**From:** Charlotte Watkins  
**Sent:** 12 April 2022 00:10  
**To:** Sarah Greenall; Planning  
**Subject:** 21/03759/F - Land East of The Leys, Adderbury

**Dr Charlotte Watkins**  
**Ecology Officer**

Figure 6 – Permanent replacement bat loft (in orange) for BLE located in loft above bin store with bat access indicated by blue star

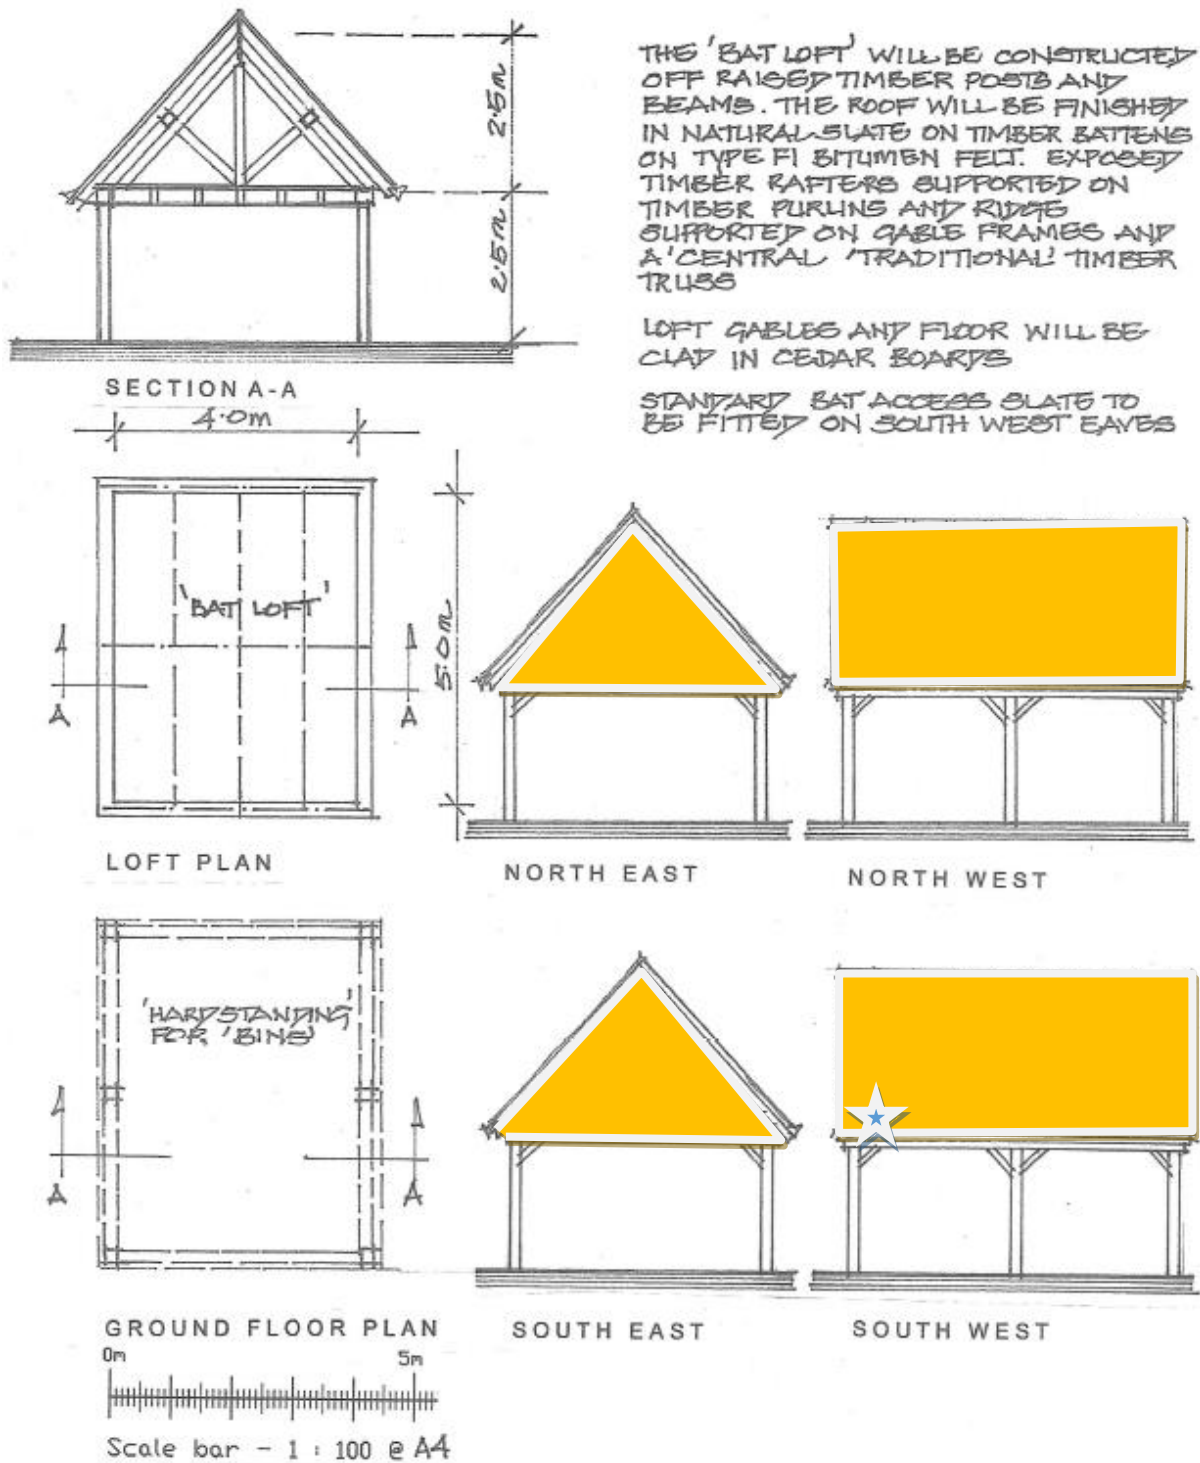
The bat survey submitted (2017) appears to refer to a barn which does not form part of this application but does involve mitigation which is sited within this application boundary. It references a bat loft above a bin store in the North West of this site however I could not find any plans showing the location of this within this application and this should be made clear so it is not missed.

**SITE LAYOUT PLAN**

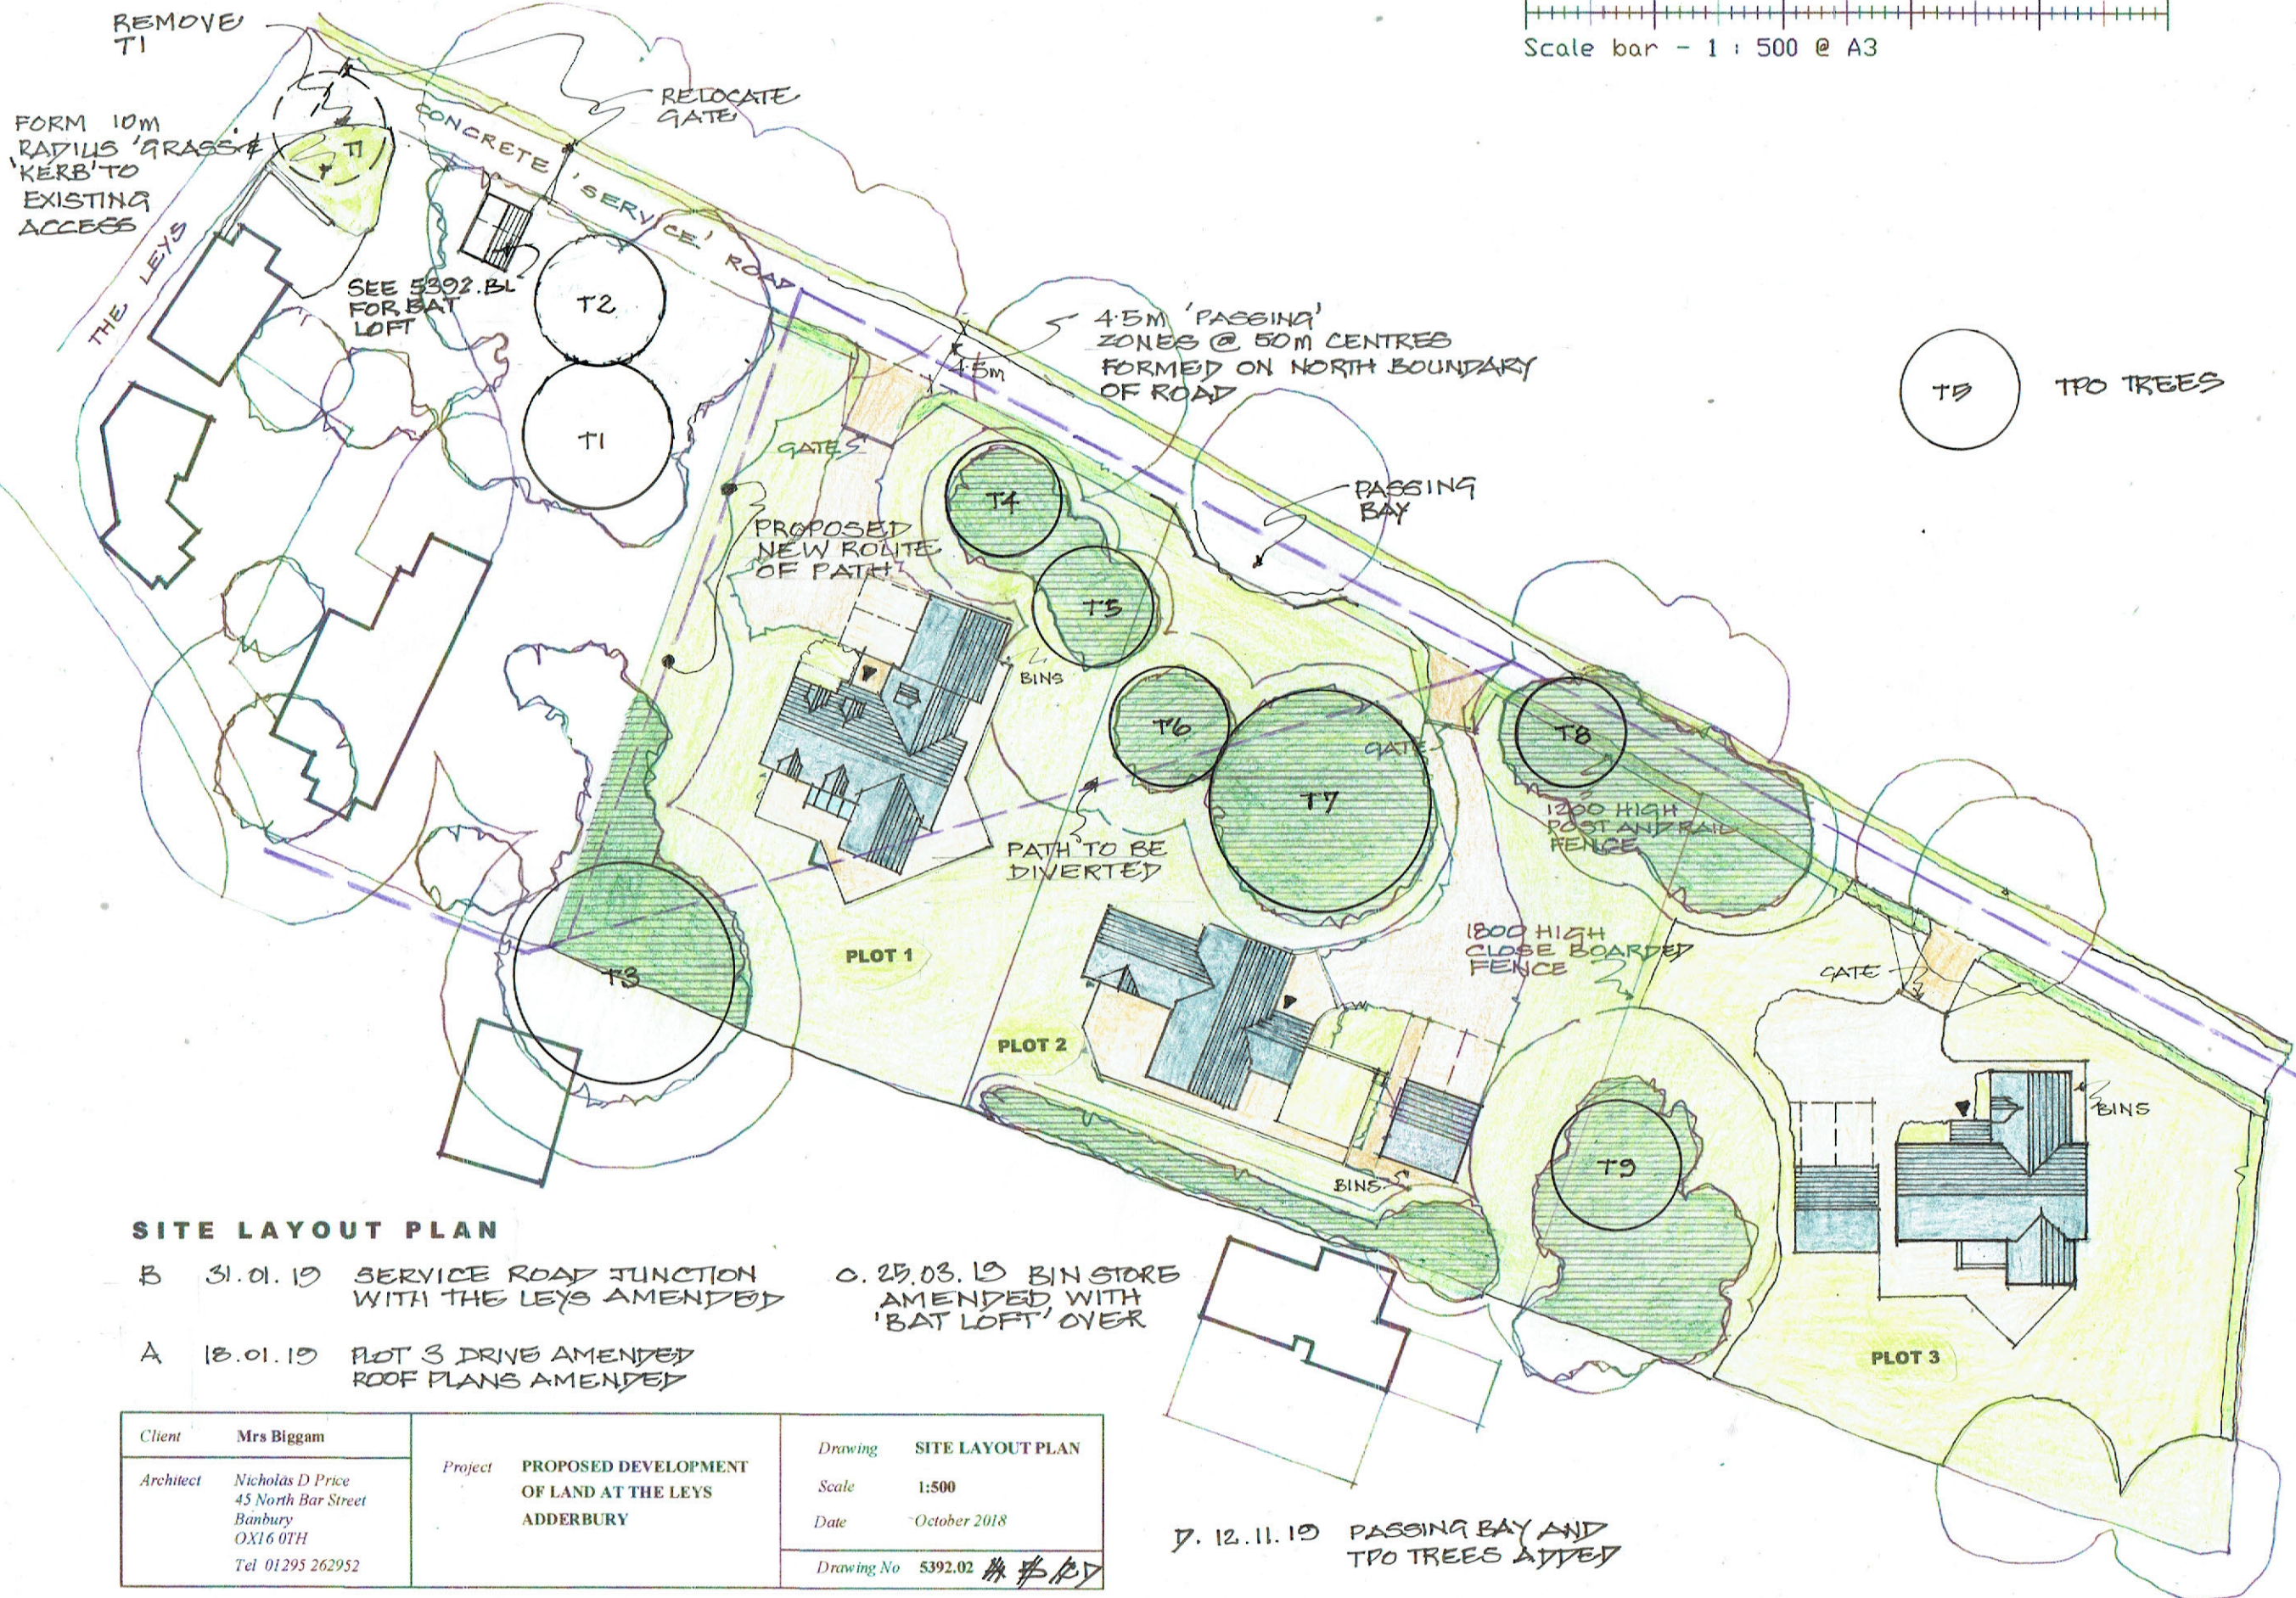
There is no demonstration within the documents that there will be a net gain for biodiversity as a result of this development. Habitat will be lost on site and is not clear that it is being replaced and enhanced. The ecological assessment suggests new hedgerows will be included but these are not indicated on the layout plan. We seek a net gain in habitats of at least 10% as calculated by a Biodiversity Impact Assessment calculation metric. Where a metric is not used (on smaller sites, which this could be said to be) the overall gain for biodiversity should be demonstrated clearly through landscaping and layout or with enhanced habitat management on adjacent areas. This is in addition to integrated bat/bird bricks within the dwellings. Currently it appears there could be a net loss for biodiversity on site and this would be contrary to policy and National guidance.
